**CITY OF PORTLAND**

re: 162 Veranda Street, Choi Institute and Martial Arts

On October 20, 2000 the Portland Planning Authority approved the site plan application for the Choi Institute and Martial Arts Change of Use located at 162 Veranda Street with the following conditions:

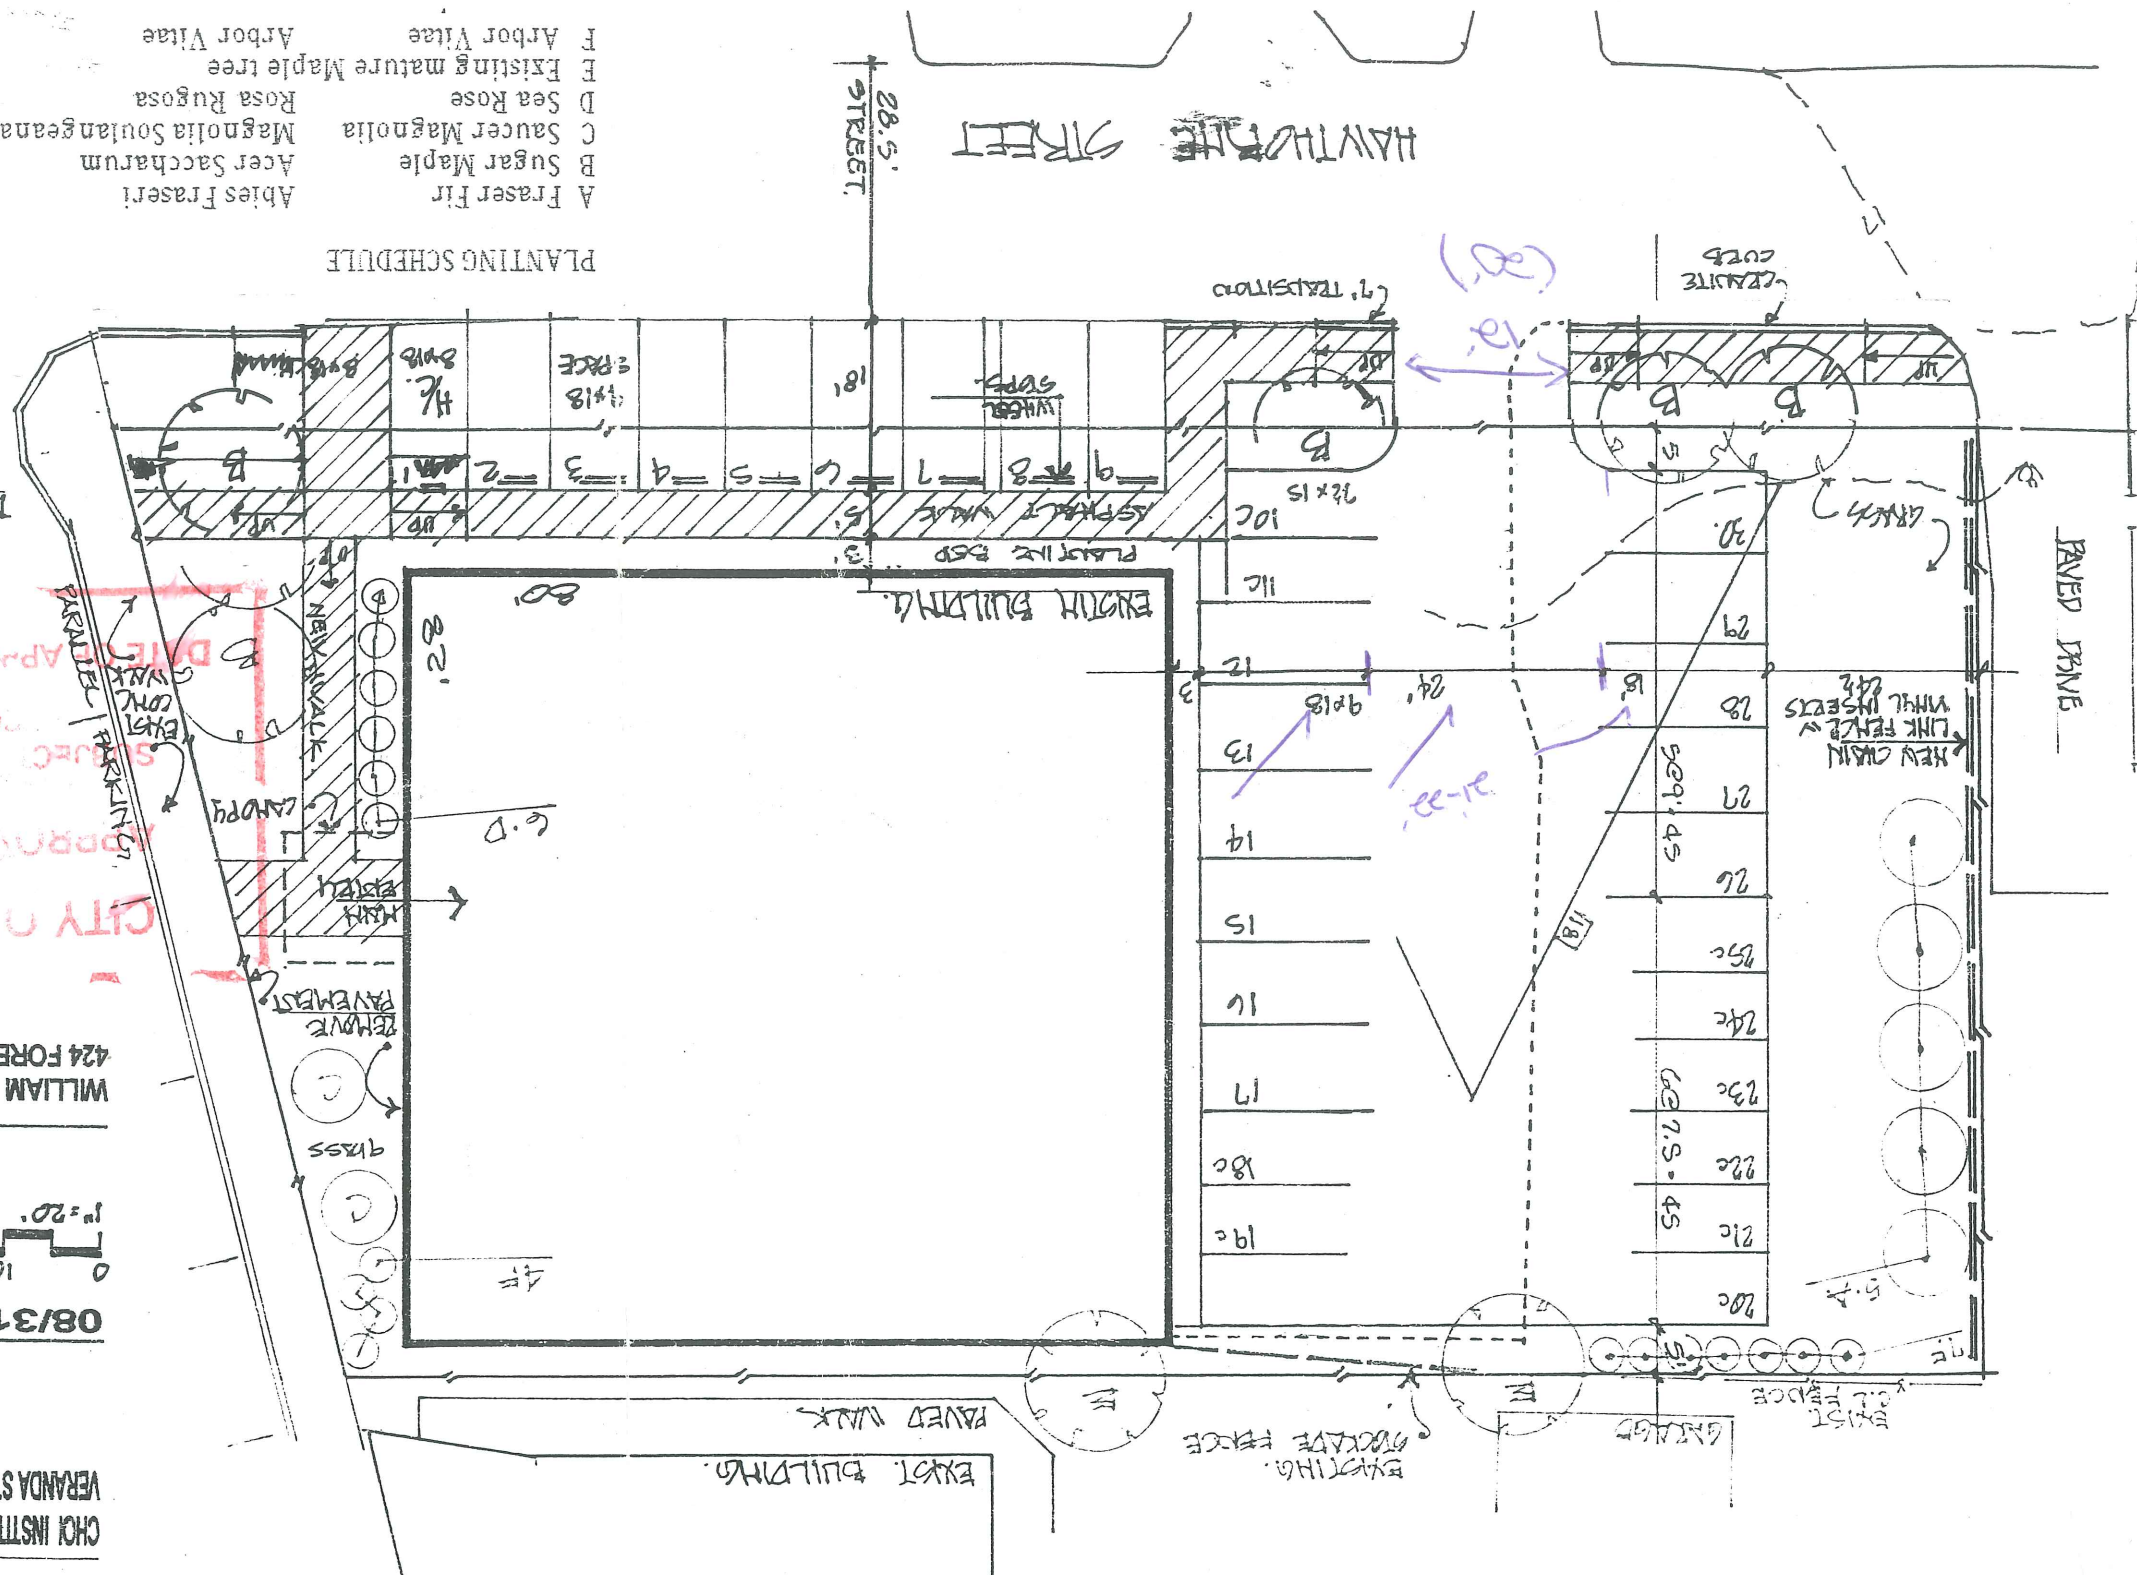
1. The asphalt sidewalk shall be built to city standards.
2. The applicant shall install an opaque fence, such as chain link with privacy slats, picket or sapling fence, not less than forty-eight inches in height between the parking lot and the westerly property line, where there is an existing residential building.
3. The applicant shall install curb stops or wooden guardrail between the parking spaces and the proposed asphalt walkway on the southerly side of the building.
4. All trees must be at least 2 ½" caliper.
